***Modification to Concept Plan MP06_0335
MOD 2 & Project Approval MP06_0209 MOD 4***

***Wollongong Central & West Keira,
Wollongong***

Director-General's
Environmental Assessment Report
Section 75W of the
Environmental Planning and Assessment Act 1979

September 2012

DRAWING TITLE:
OVERALL FLOOR PLANS
LEVEL 1 LOWER GROUND FLOOR
RETAIL

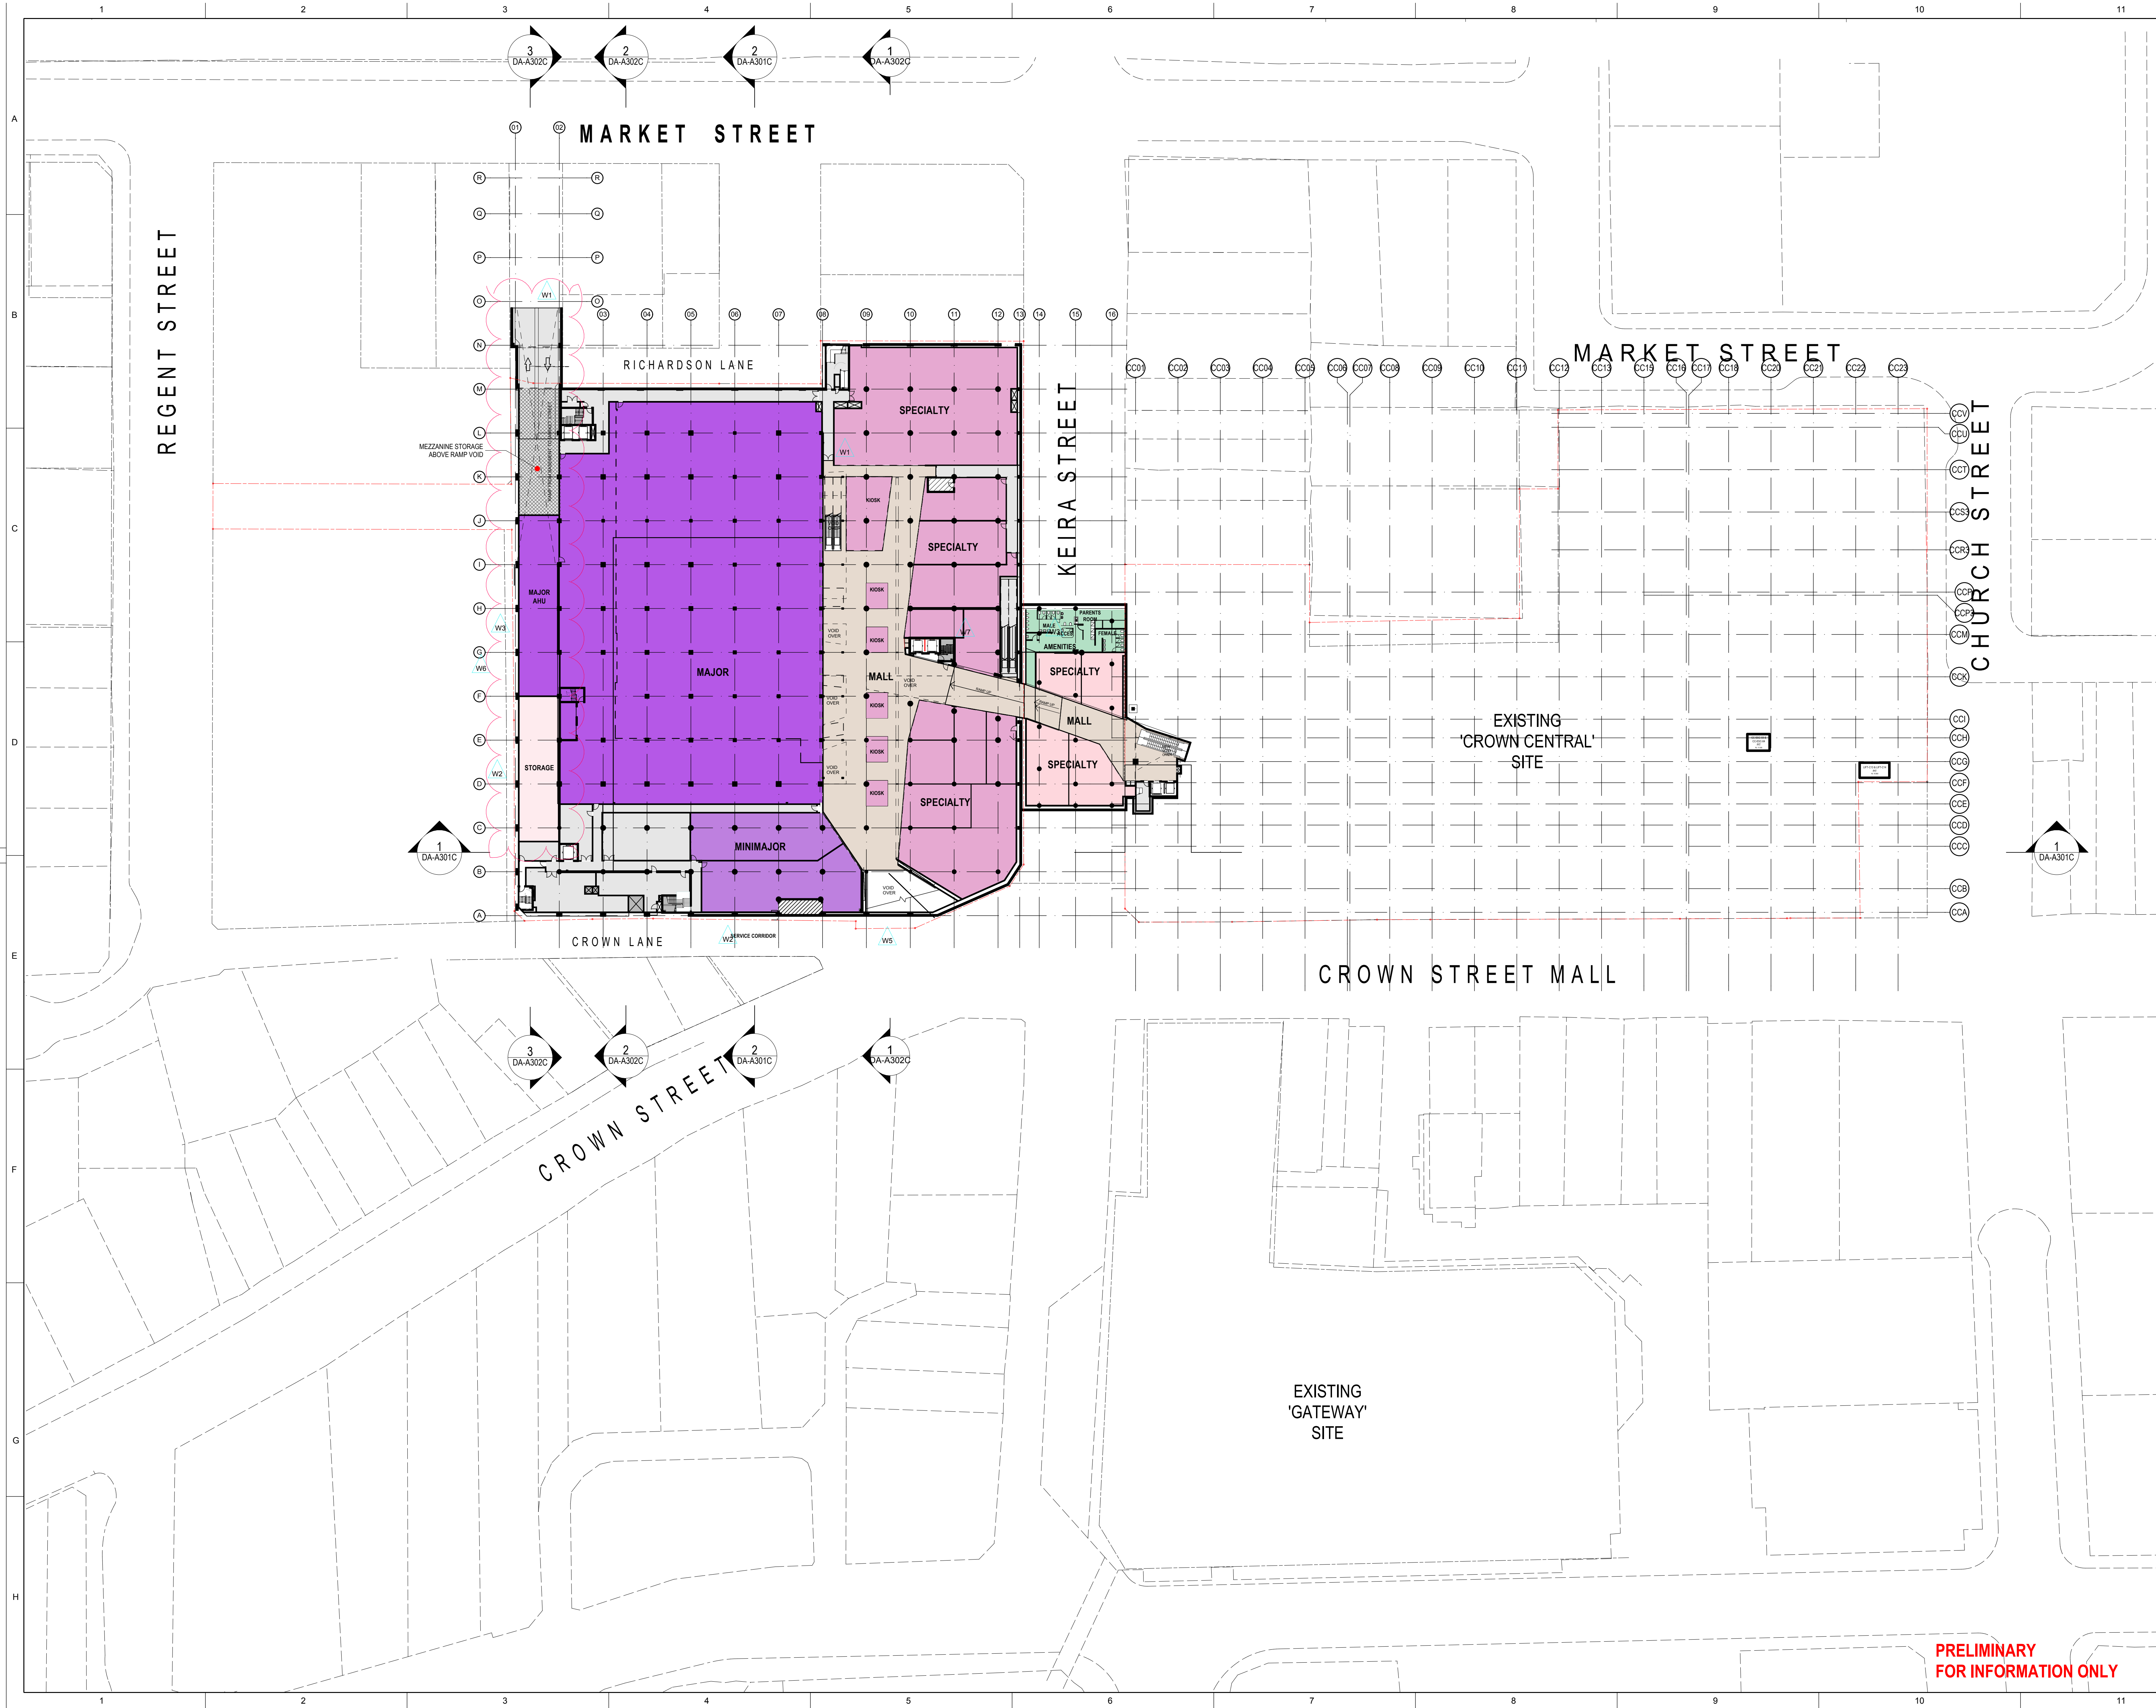
Why has the land between No 71 + the WK site been excluded from the application? Given this project application proposes to develop this land, I would have thought it was essential to include it and to obtain land owner's consent for the development of the land.

DRAWING TITLE:
WEST KEIRA
MARKET ST ELEVATION

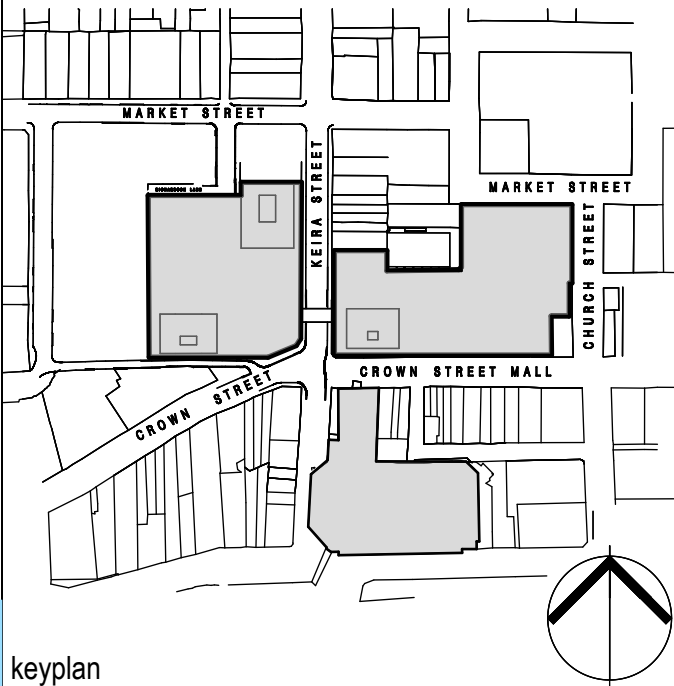
The proposed new vehicle crossing to Market Street will include a façade structure with a height of 16.6 metres above street level, constructed of white patterned pre cast walls, offset by a steel entry portal at street level (**Figure 7**). The structure will conceal the upper level storage area, above the vehicle ramp. The façade structure has been designed to reference the approved West Keira shopping centre frontages to West Keira and Crown Streets (**Figure 8**).

The proposed structure will exceed the height of the adjoining buildings at No. 67-69 Market Street and No. 73 Market Street however, the structure will be well below the maximum building height for the site, permitted by the Wollongong Local Environmental Plan 2009 (32 metres) (**Figure 9**).

For the above reasons, the Department supports the proposed façade design of the customer parking area. Council did not raise any objections to the proposed façade design.
